SKP/15230-06
26th July 2017

JOB TITLE Skimmingdish Lane		CLIENT Albion Land	
DRAWING TITLE Max Legal Artic Tracking			
SCALE 1/500@A3	DRAWN BY BP	DATE July17	DRAWING No 15230-18
		REVISION

07 SITE PLAN
012 KEY

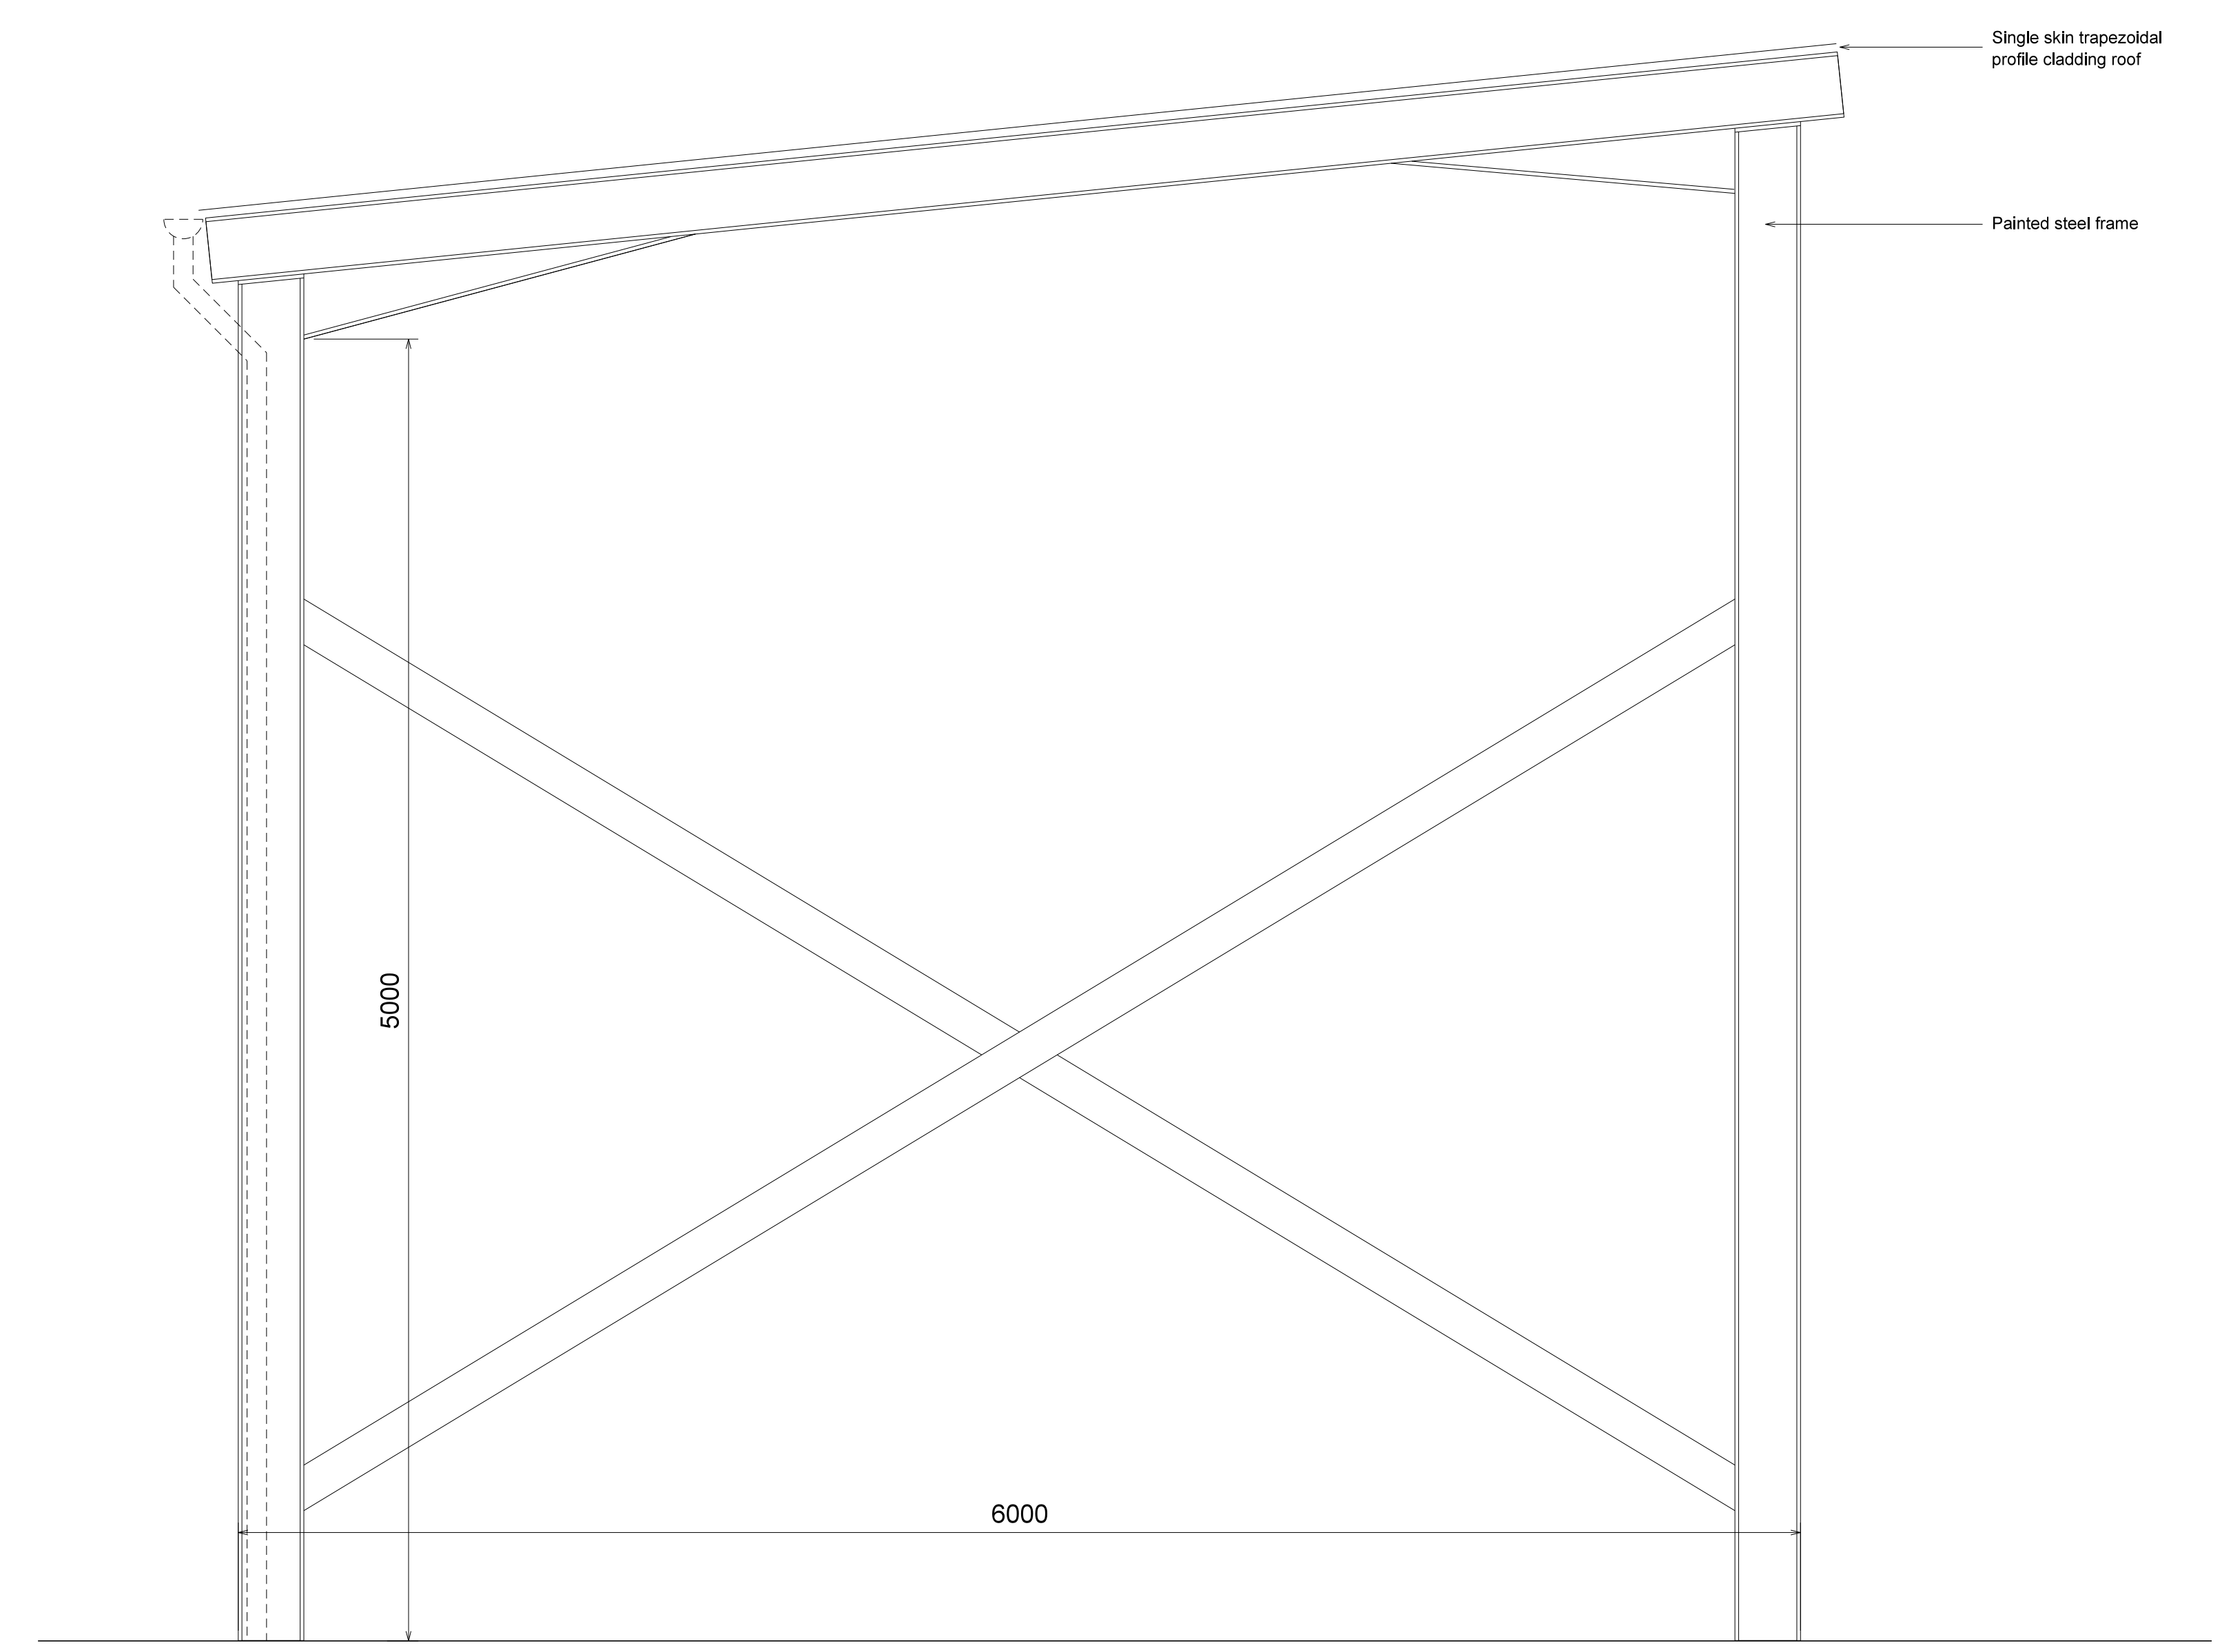
- 2.0 To respond to this, it is accepted that Unit 3B will be subject solely to a B8 consent, whilst retaining flexibility across the land use classes on Unit 3A. In terms of cycle parking, 6 stands (12 spaces) are provided for Unit 3B at a rate of 1 space per 320sqm of B8 floor-space. Twelve stands (24 spaces) are provided for Unit 3A at a rate of 1 space per 155sqm GFA. This meets the requirement for B1(c)/B2/B8.

- 3.0 In terms of the car parking provision, Unit 3B spaces accord with the B8 use class (24 spaces including 3 blue badge spaces). Unit 3A comprises 62 spaces, including 3 blue badge spaces which equates to 1 space per 60sqm GFA. The parking standards, expressed as maxima are 1 space per 50sqm for B2 and 1 space per 200sqm for B8, giving a range of 19-74 spaces. The proposed level is appropriate to respond to the flexibility of prospective occupants within the B1(c)/B2/B8 use classes.
